431 Congress Street Change of use

I am applying for a change of use for 431 Congress Street, A Moveable Feast. We are a catering company that would also like to use our front room as a restaurant for lunch. I will wait to hear from you so that I can make payment as outlined in your requirements for electronic submission. Thank you.

Proposed floor-plan change

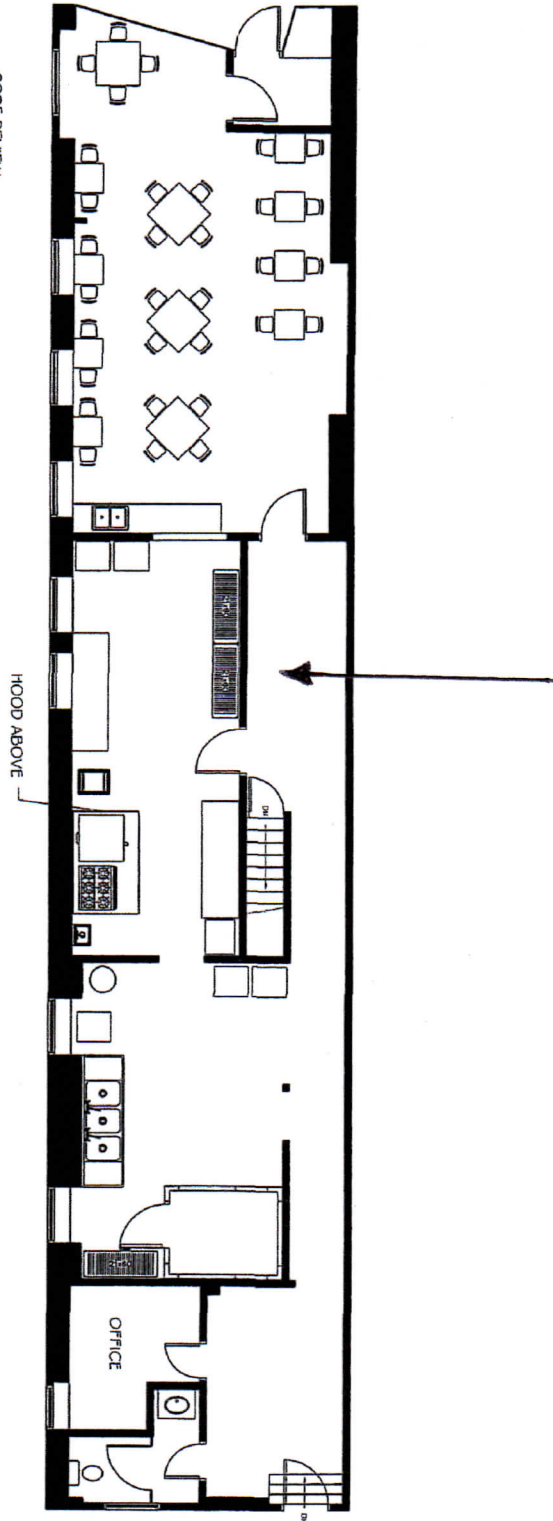
We are performing a preliminary completeness check of the documents you submitted with your permit. Would you please resubmit your Floor and Key Plan document after marking the area that will be sheetrocked? It is hard to tell where the sheetrock will be installed.

Hello Stephanie,
I added 2 feet on each side of the door. Does that help ?
Noel
